OBSERVATION/SUBMISSION TO PLANNING APPLICATION

Case Reference: 324162

Re: Observation to the proposed development of a 220kV substation, telecommunications mast and underground electricity cable infrastructure with associated works.

Applicant: Bord Gáis Energy Limited

SHEET TITLE  
 220kV Ducts in Local Road Temporary Reinstatement (SDI) With ECC

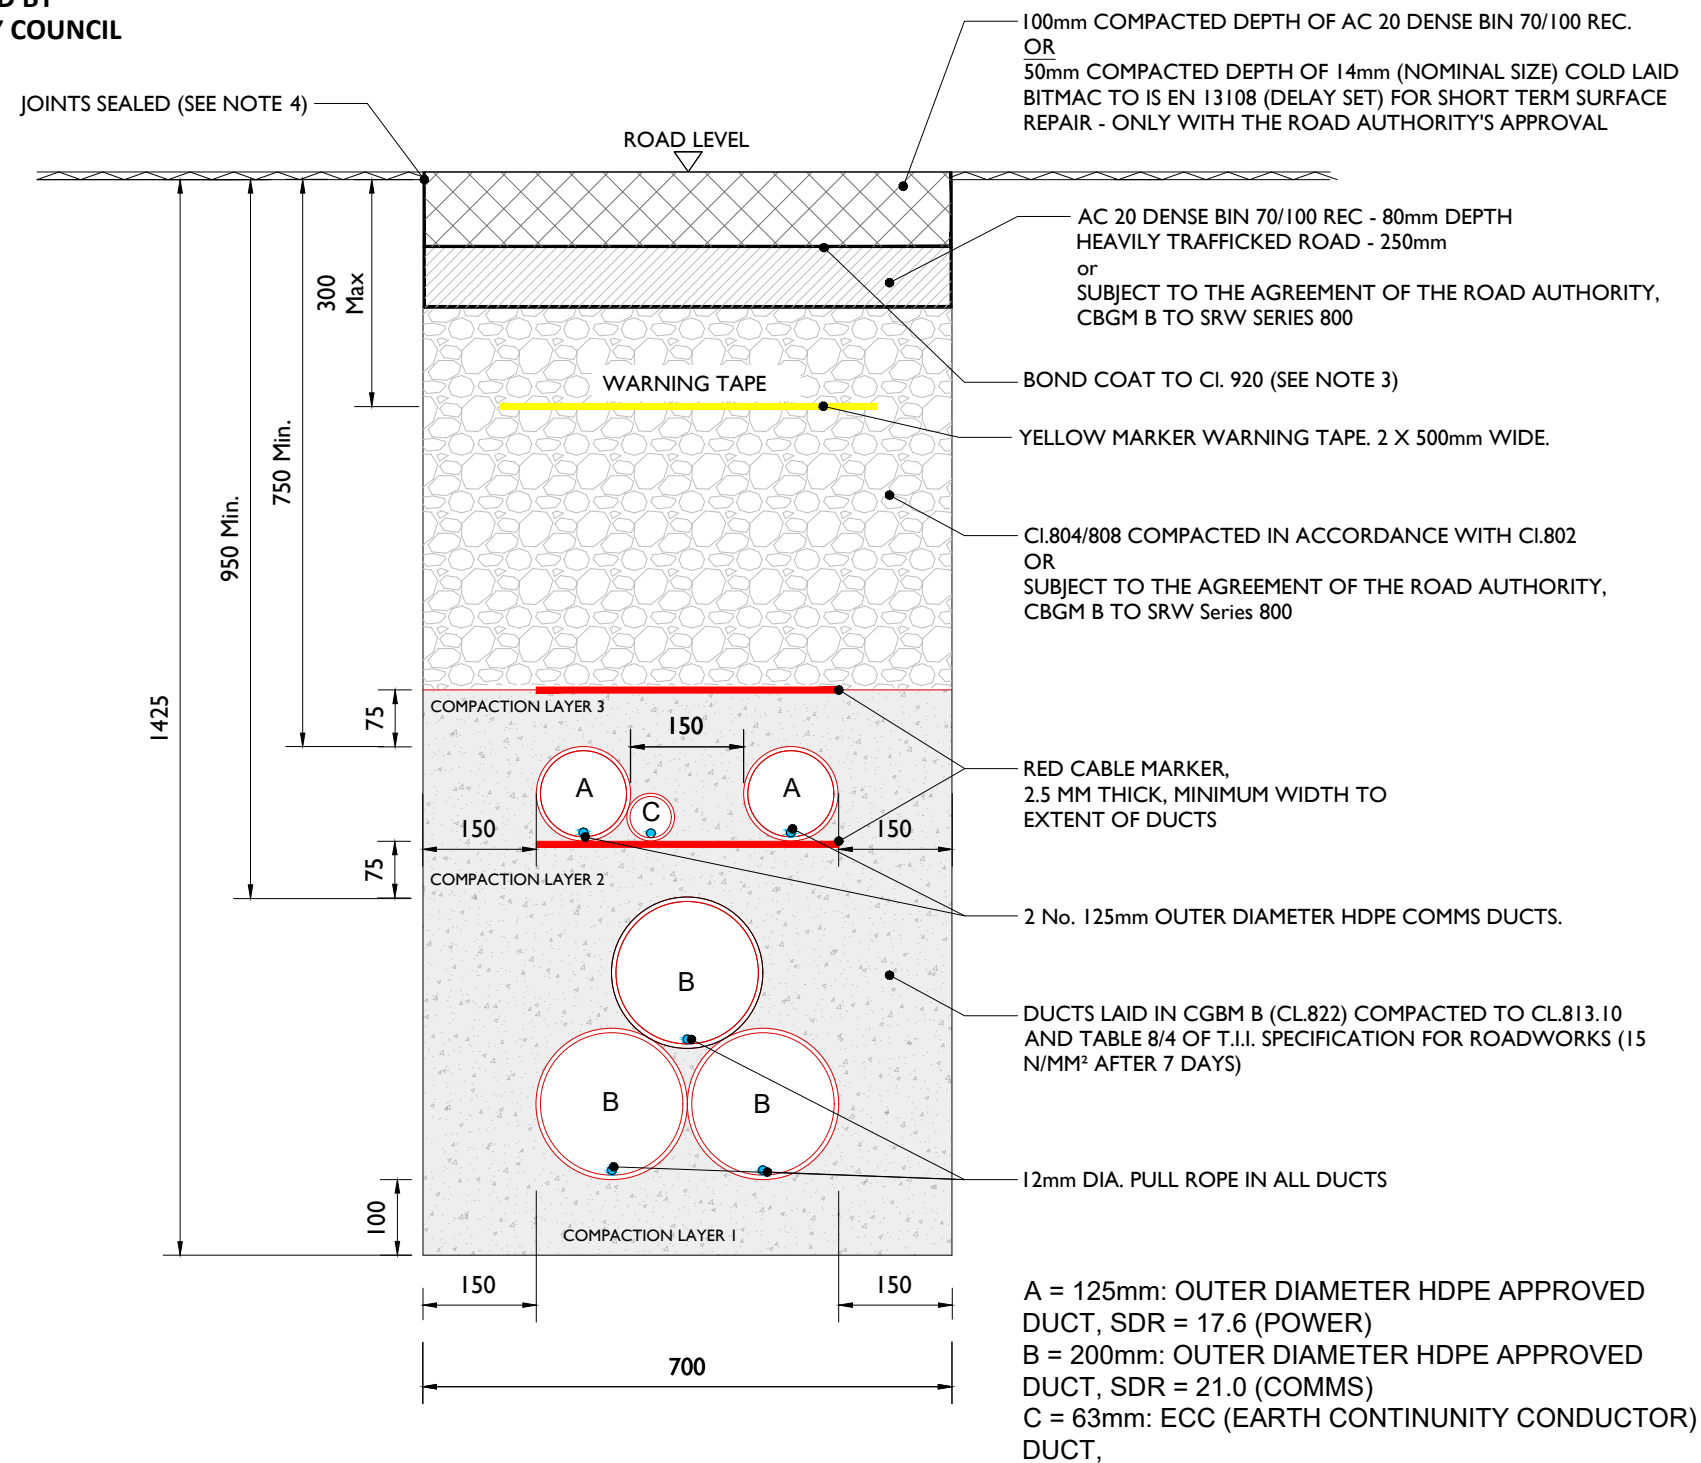
A further concern is the risk of damage to the entrance area and tarmac directly adjoining my property. Any excavation or heavy construction activity in this location creates a real risk of damage, poor reinstatement, and long-term deterioration in the surface and approach to my home. Clear assurances are required in this regard.

220kV Cable Ducts in Off Road /
 Grassland Section With ECC

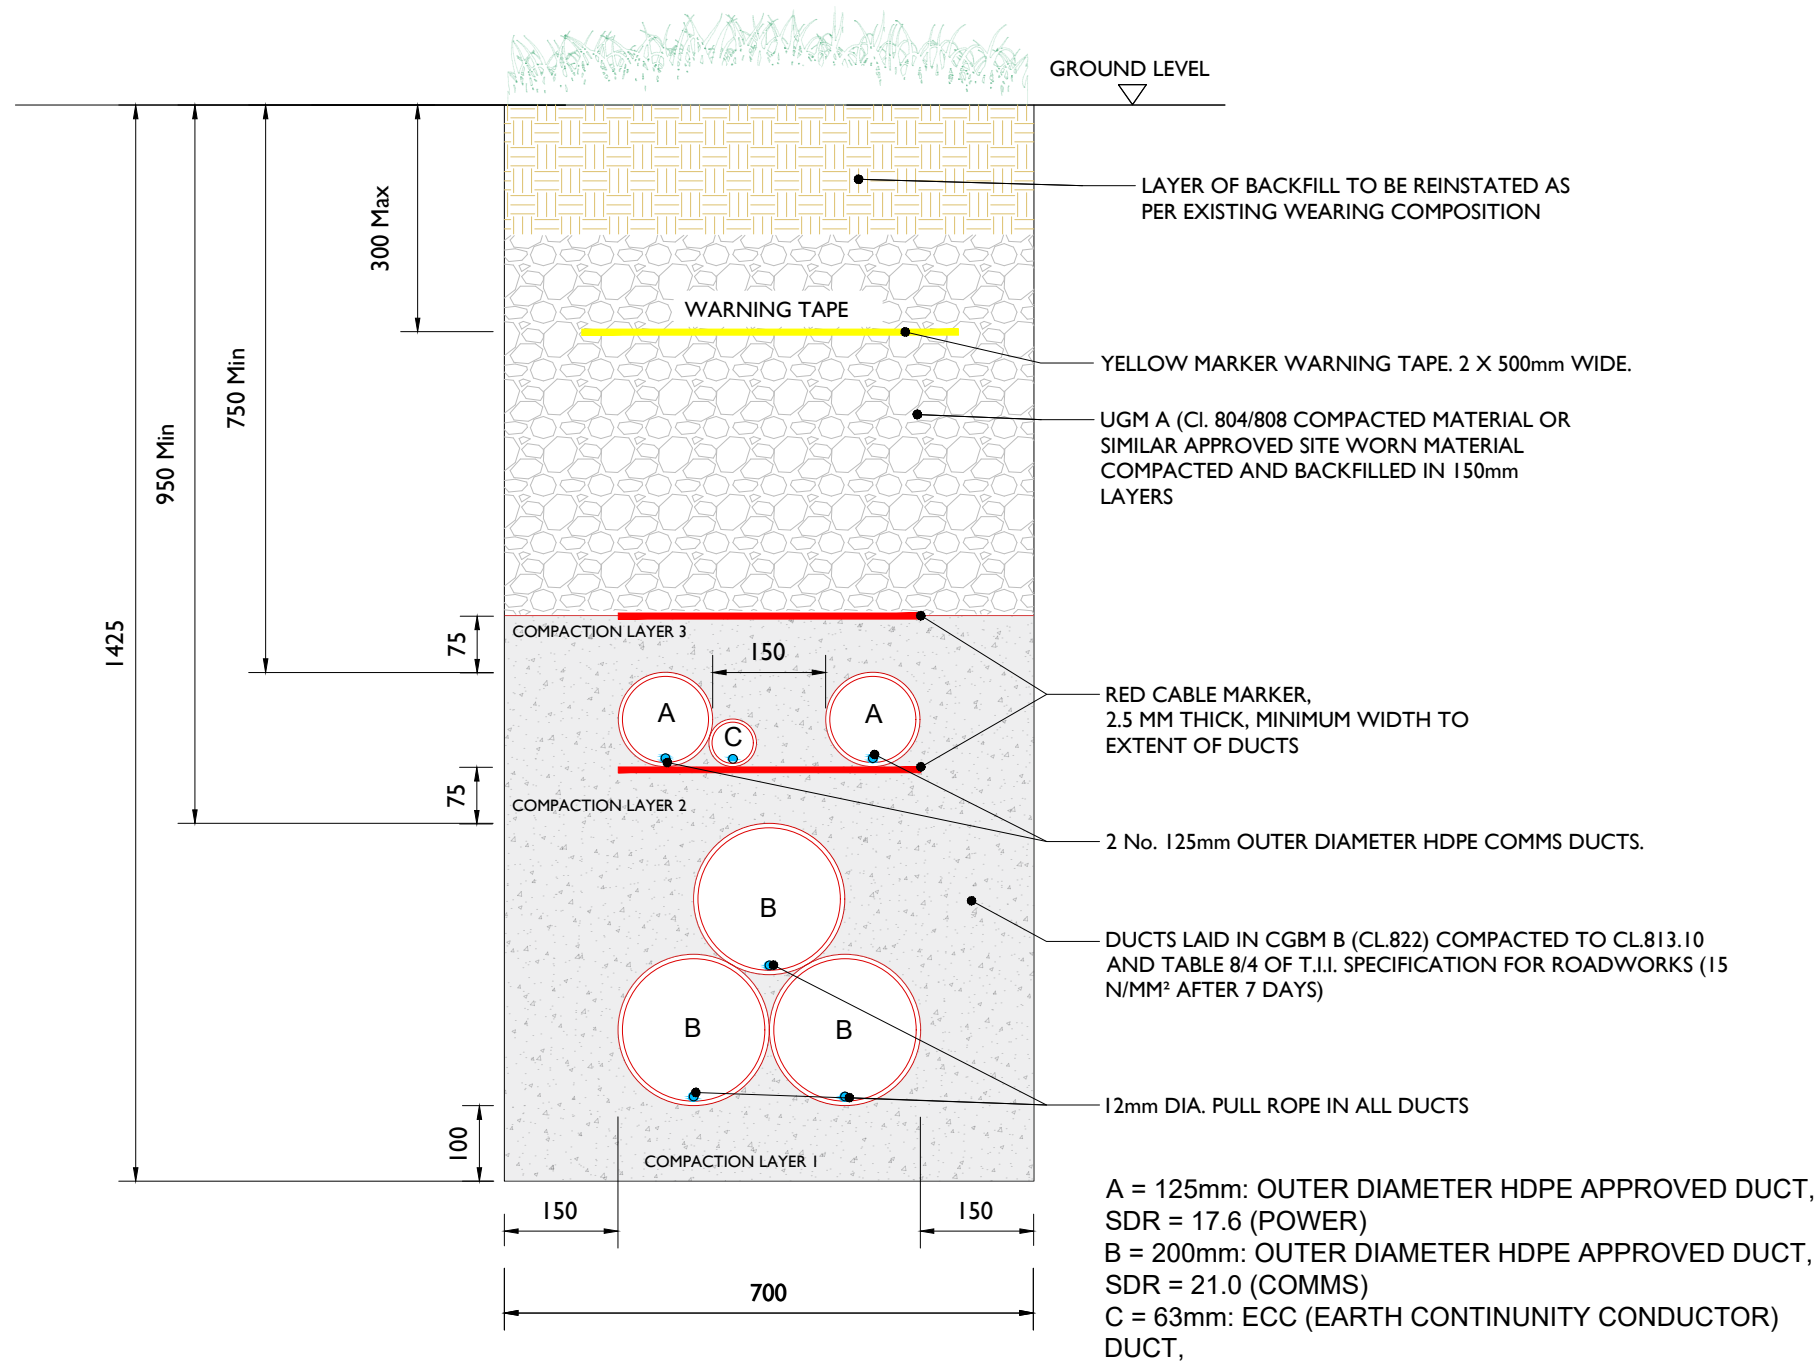
I do not believe sufficient information has been provided regarding how mature trees, hedgerows and root

systems would be protected during construction works or how damaged vegetation would be reinstated afterwards. In my view, the long-term maintenance, stability and safety implications for roadside trees and boundary vegetation have not been adequately addressed.
